**RE: Sydney Grammar School, Weigall Sports Complex: State Significant Development (SSD-10421):  
Response to Condition B1**

This letter on the Sydney Grammar School Weigall Sports Complex (SSD-10421) is written on behalf of Sydney Grammar School. It responds to SSD-10421 Condition B1 which states:

- B1. Prior to the issue of any construction certificate, the design of Building 1 (Sports Complex building) must be amended and revised architectural plans and documentation demonstrating compliance with the condition must be submitted to, and approved by, the Planning Secretary. The revised design must modify the design of that part of Building 1 located directly opposite 8 Vialoux Avenue (i.e. the building component east of the Building 1 stair core/Multipurpose Hall 4 and including the area above the program pool) to reduce the view loss impact experienced by the north facing living rooms within apartments 1, 5, 8 and 12 at 8 Vialoux Avenue. The amendments to the design must comprise (unless otherwise agreed with the Planning Secretary) the following:

Drawing Title
**WEIGALL SPORTS COMPLEX
BUILDING 01 AND BUILDING 02
APPROVED SSDA / RESPONSE TO B1
CONDITION COMPARISON (SHEET 3)**
Sheet Status
NOT FOR CONSTRUCTION

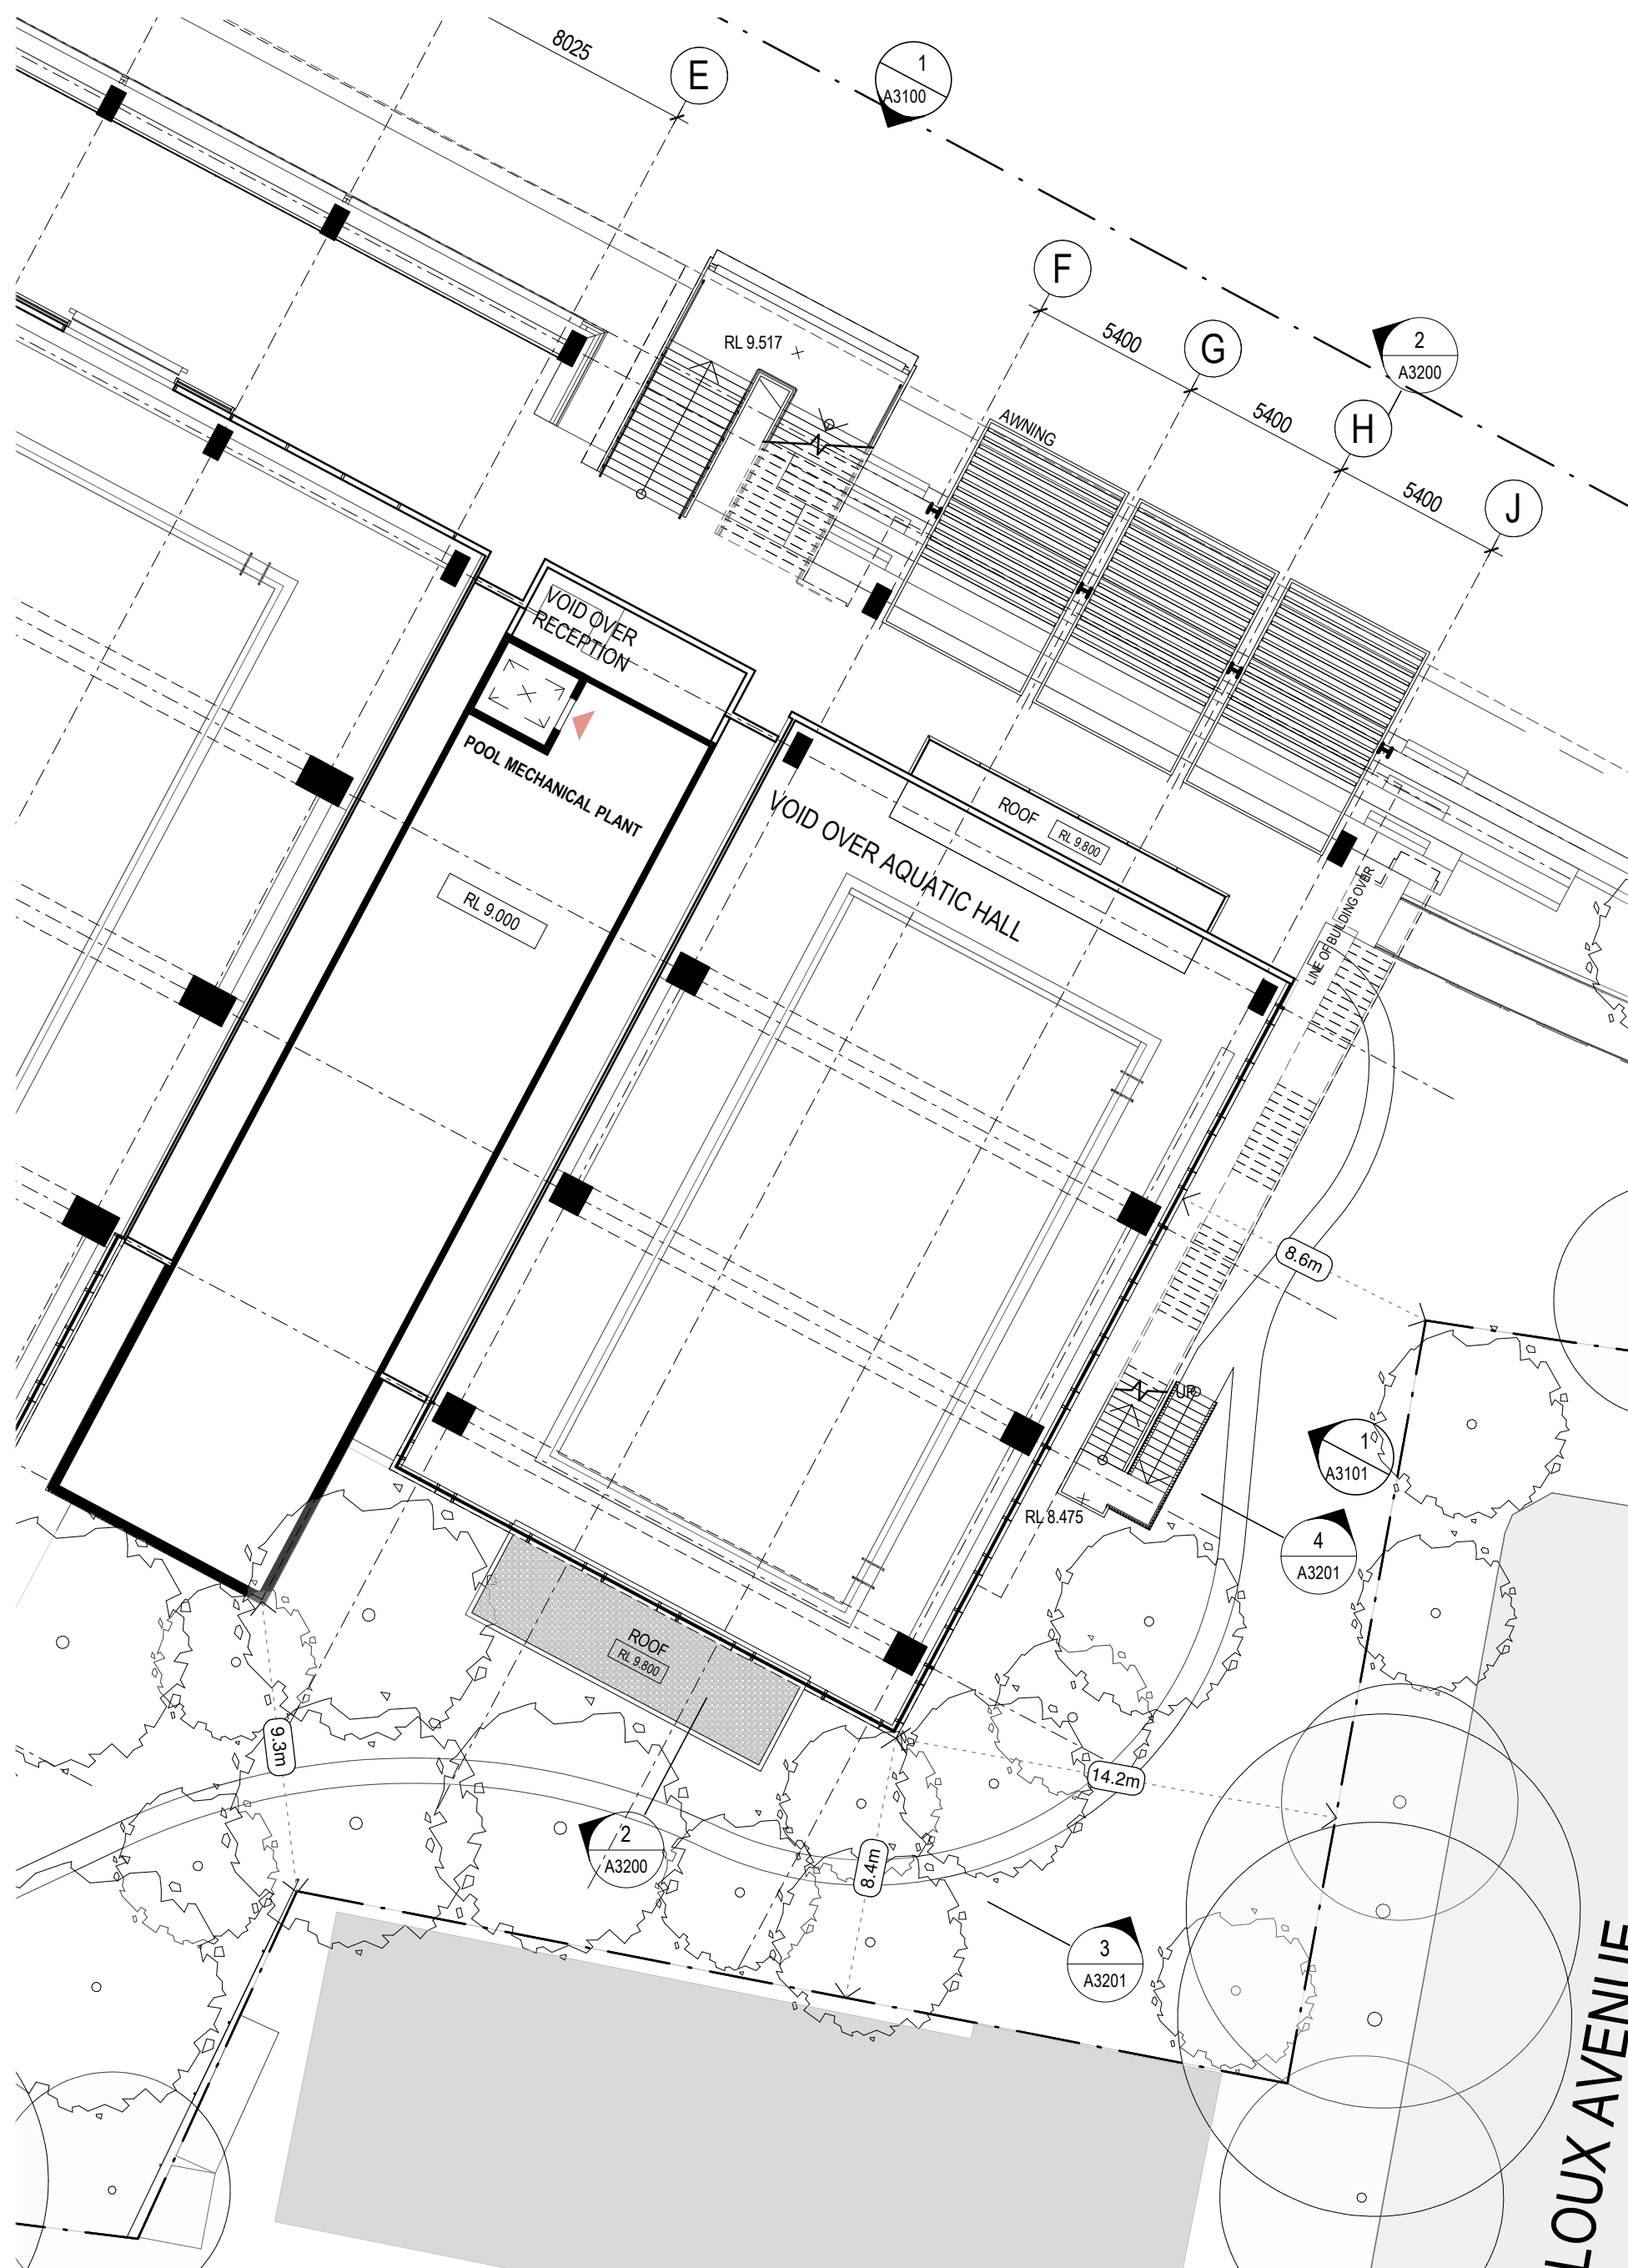
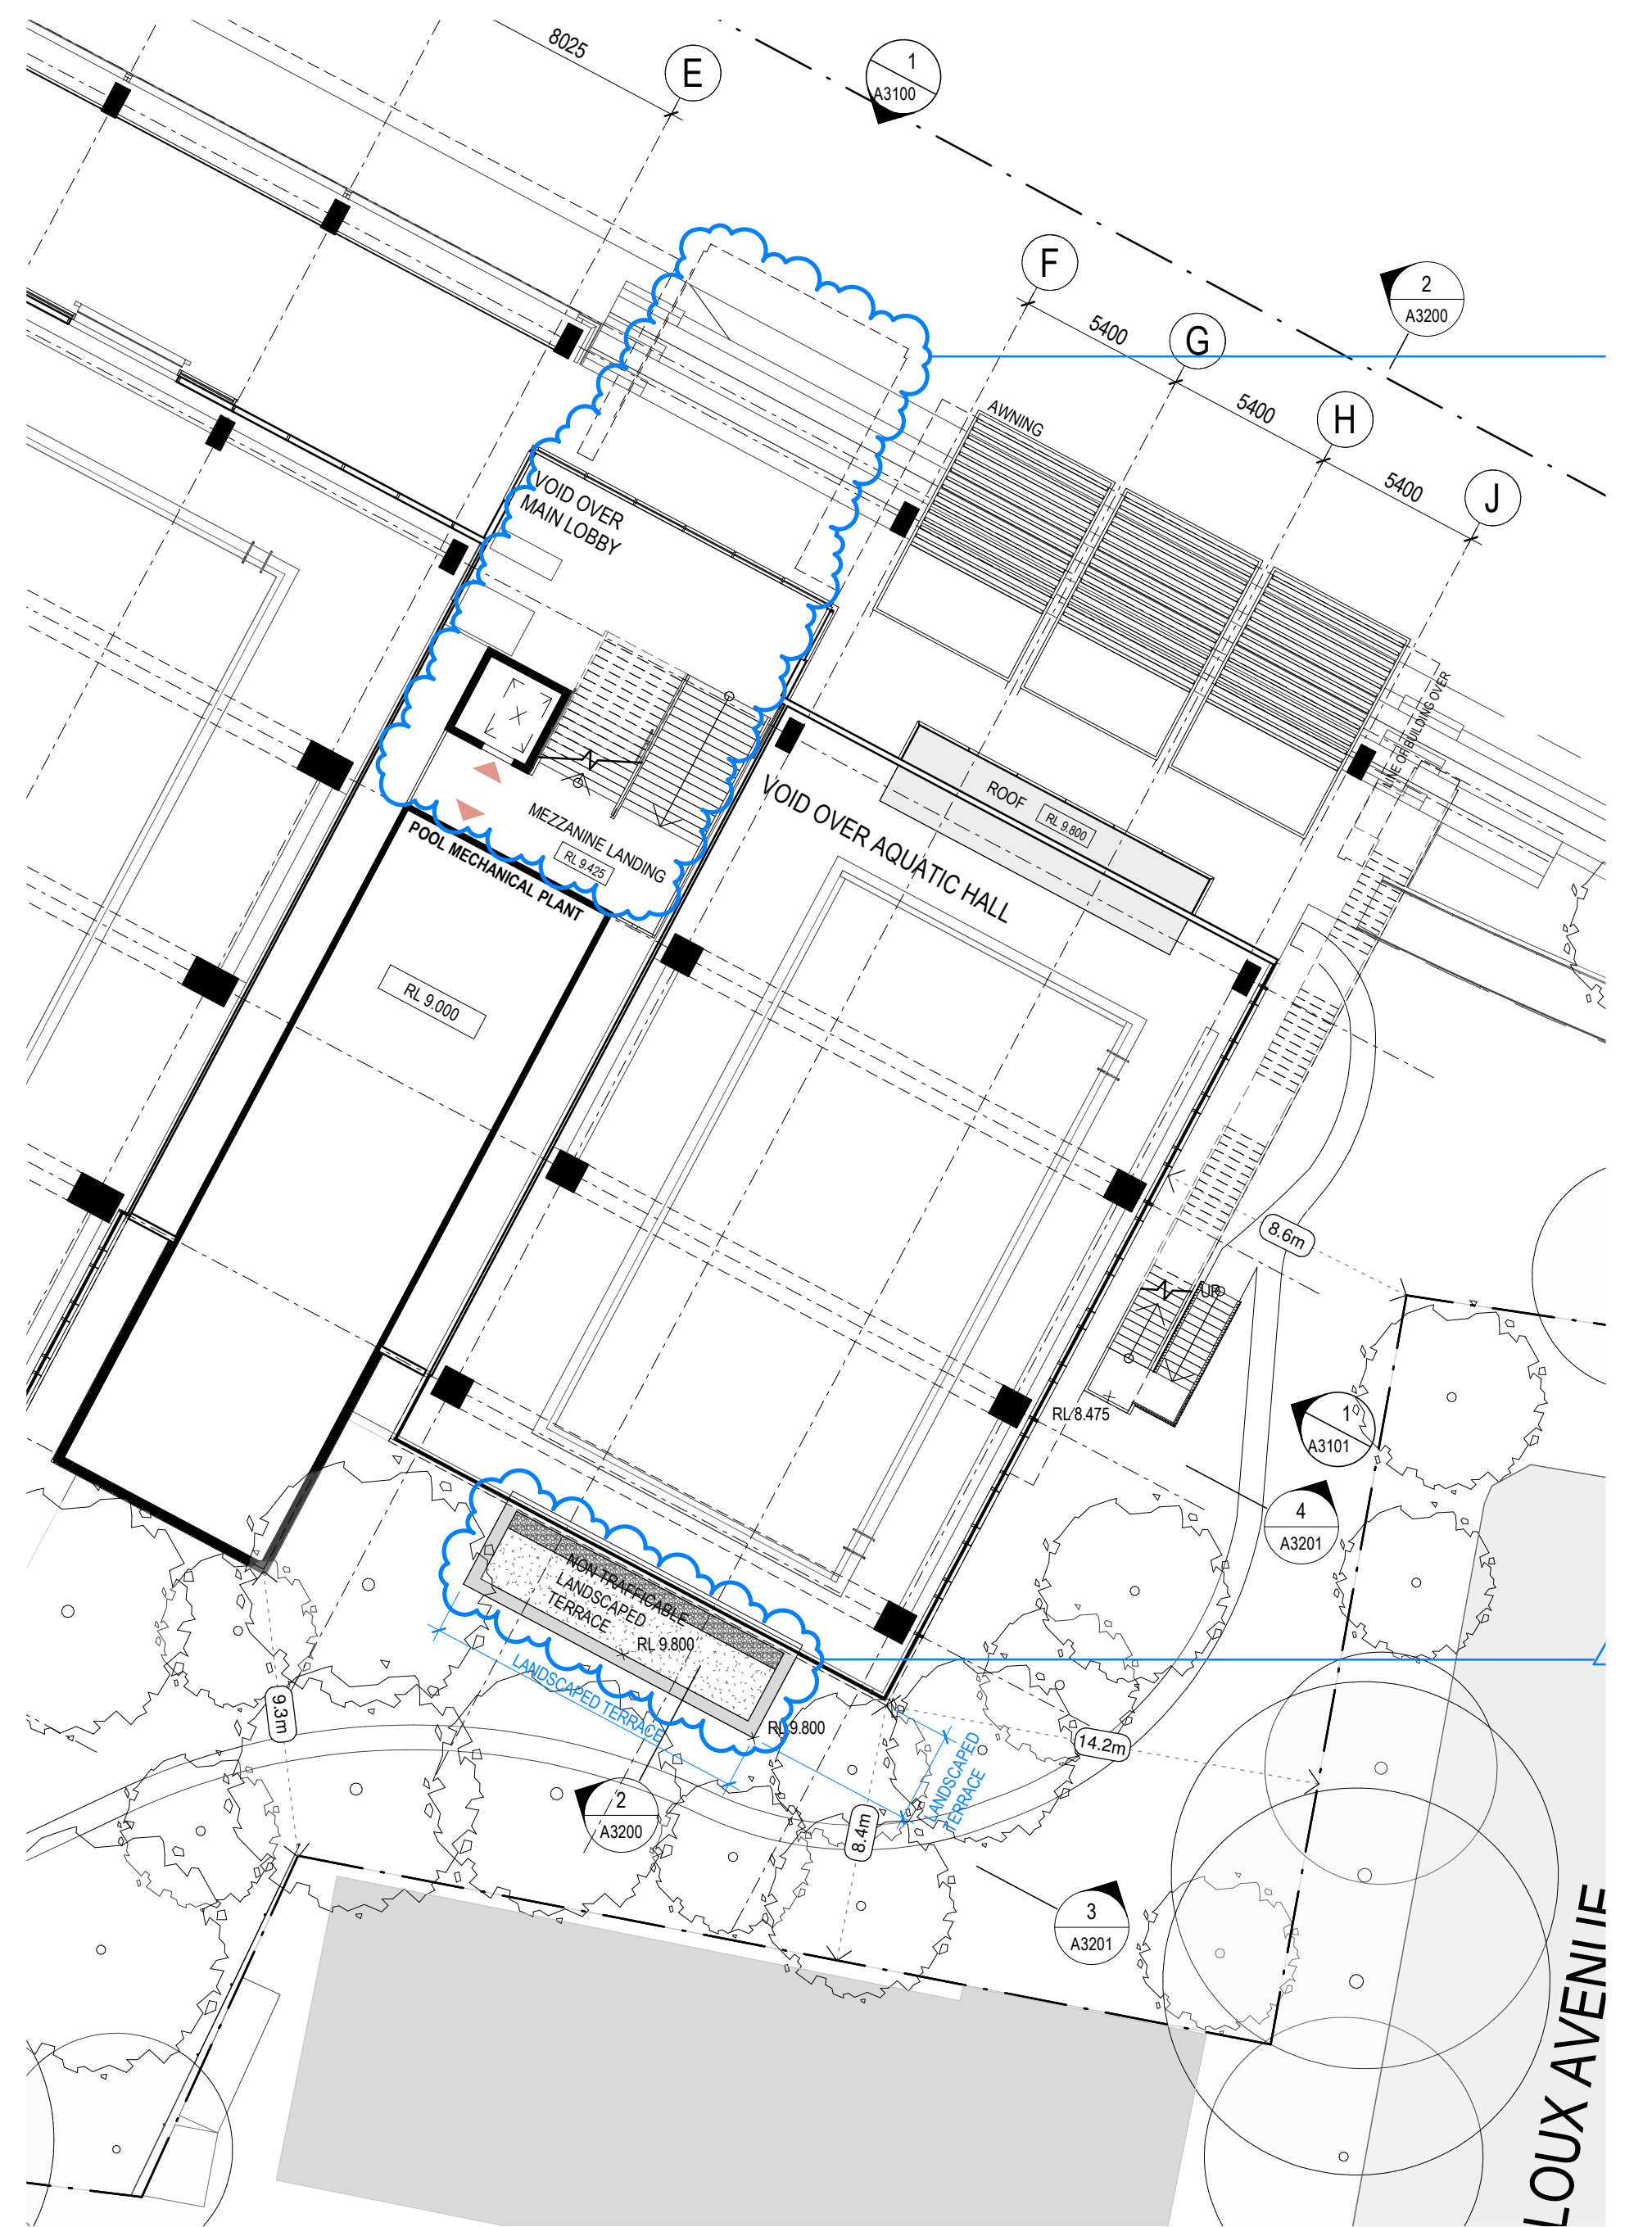
6. Redistribution of the approved plan area as Design Amendment 5 reduced the area of plant on the Mezzanine Level (-40.9m<sup>2</sup>), necessitating a similar increase to the area of plant at the Basement Level (+36.35m<sup>2</sup>). The additional Basement Level plant is beneath the Building 1 footprint and will not alter the envelope/external appearance of Building 1 or the approved landscape design. The design amendments result in a small overall reduction in the total plant area (-4.55m<sup>2</sup>), as summarised in **Table 1**.

Area of Plan	Approved SSD Revision C	Condition B1 Design Amendment Revision E	Proposed change
Mezzanine Plant (m <sup>2</sup> )	211.46	170.56	-40.9
Basement Plant (m <sup>2</sup> )	271.85	308.2	36.35
<b>Total (m<sup>2</sup>)</b>	<b>483.31</b>	<b>478.76</b>	<b>-4.55</b>
